M25 Junction 28 Improvements TR010029

8.1 Statement of Common Ground with the Environment Agency

STATEMENT OF COMMON GROUND

This Statement of Common Ground has been prepared and agreed by (1) Highways England Company Limited and (2) the Environment Agency.

**Figure 2.4: Proposed floodplain compensation areas**

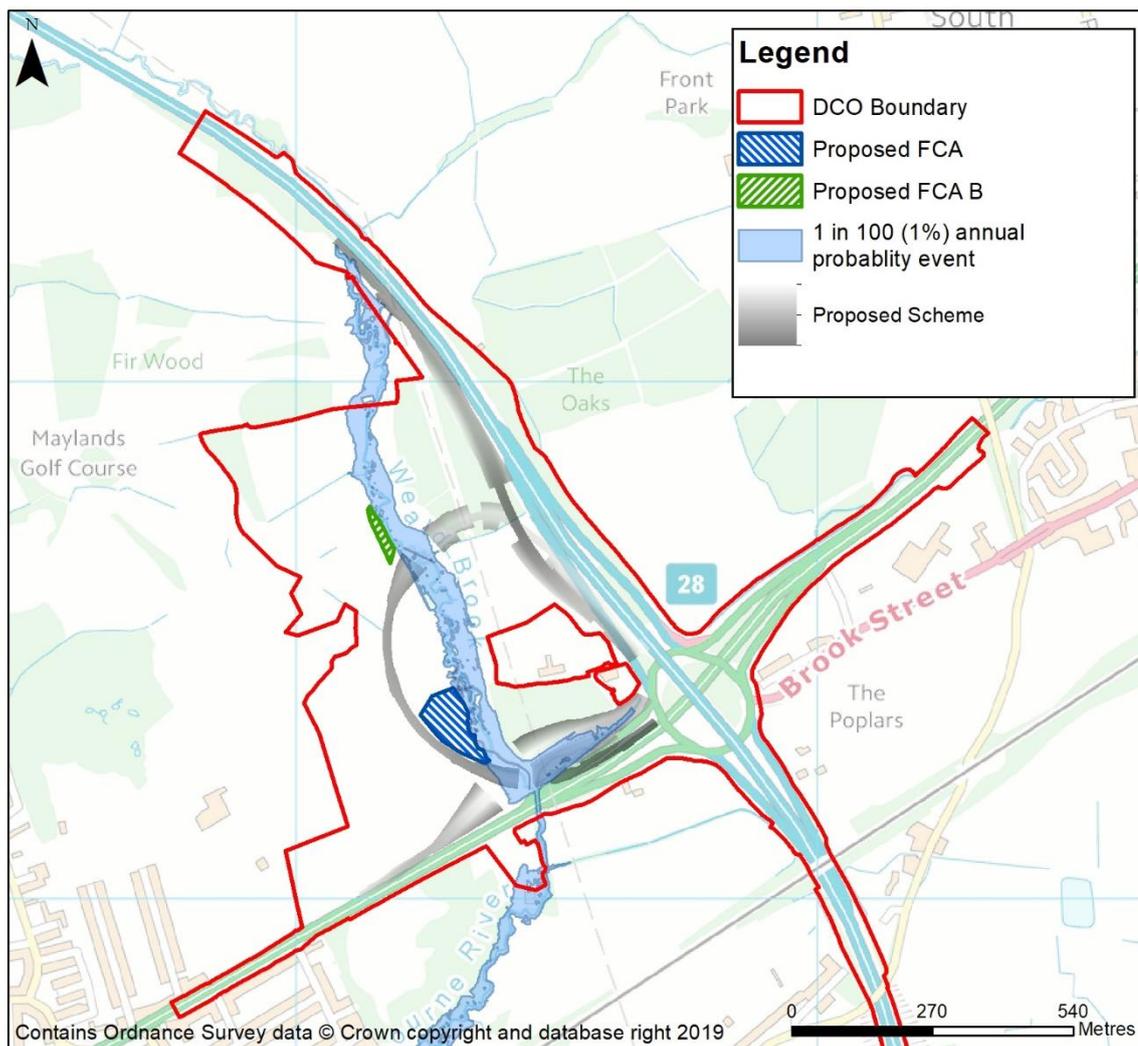
FR06	Road Drainage and the Water Environment	Flood storage opportunities	The Defra 25 Year Environment Plan advocates expanding the use of natural flood management (NFM) solutions to reduce risk from flooding (and coastal erosion). The EA encourage incorporation of NFM into the Scheme, where appropriate. In particular, the EA would welcome being involved in consultation on proposed alterations to the river floodplain required for the Scheme and the multiple use of flood compensation areas (different types of wet woodland).	The DCO design includes lowering the floodplain between the new A12 slip road and the Loop Road, increasing connectivity of the Ingrebourne River to the floodplain. The design also includes lowering the base level of the floodplain compensation areas below the level required to provide the necessary compensation storage. The design of these elements of the Scheme has been developed in consultation with the EA to provide a better connection between the river and floodplains of the River Ingrebourne and the Weald Brook	Agreed

**Figure 6-1 – Changes to climate change flood outlines as a result of the proposed scheme**

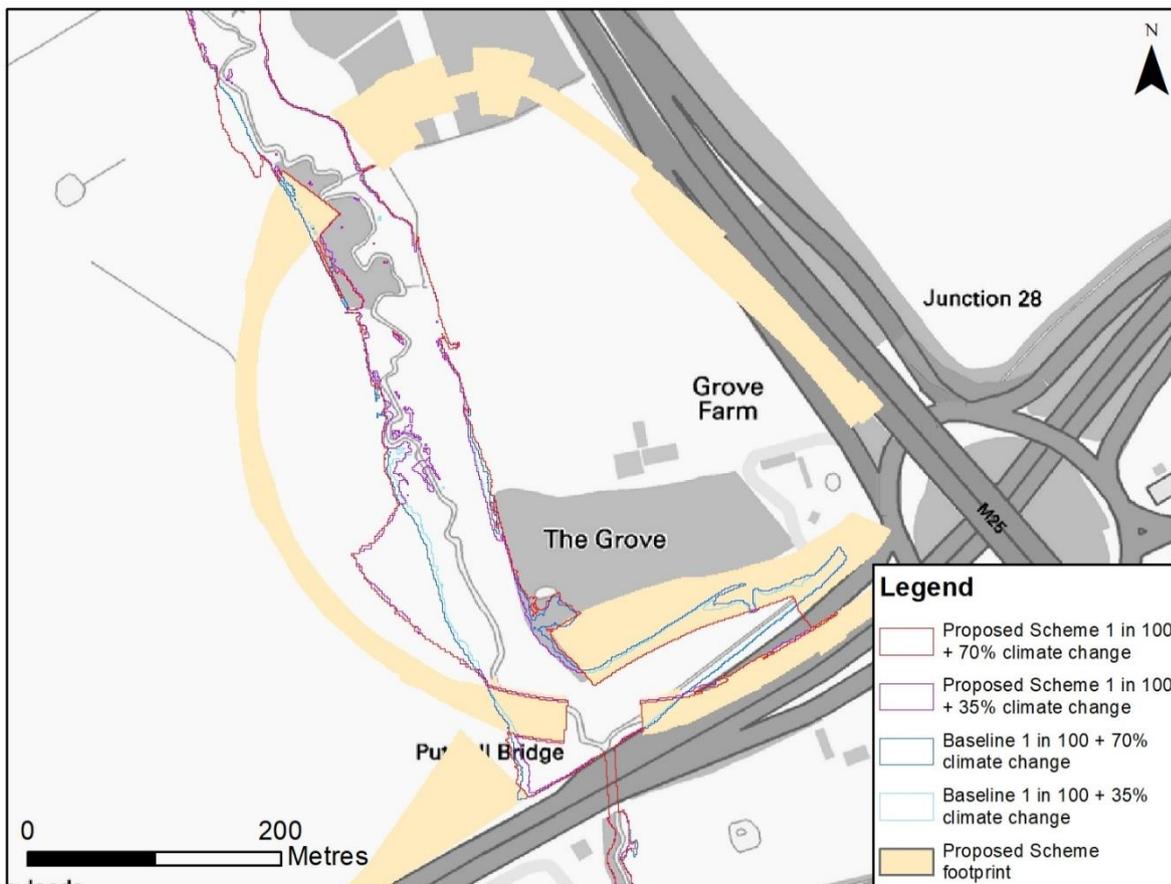
FR03	Road Drainage and the Water Environment	Flooding	The EA has agreed that the 1 in 100 year 35% allowance for climate change flood event is acceptable to design to, provided there is not a significant increase in risk between the 35% and 70% scenarios. Based on the submitted FRA, it would appear that the 35% scenario has been used as the design flood event. However, the FRA should include details of the depths and extents for both modelled scenarios so a decision on whether the 35% scenario is suitable for use can be made.	The Flood Risk Assessment has been updated to include further details on the flood levels associated with a 70% climate change allowance. This has been reissued to the EA for review.	Agreed
FR04	Road Drainage and the Water Environment	Flooding	The EA Scoping Opinion for this scheme requested that, in terms of flood storage compensation, a scheme of this size should look to produce an overall reduction in flood risk, as opposed to just ensuring the situation is not made worse. We would like to be provided with a detailed	The Flood Risk Assessment has been updated to clarify the volume of storage provided both in the 35% and 70% climate change scenario. This has been reissued to the EA for review.	Agreed
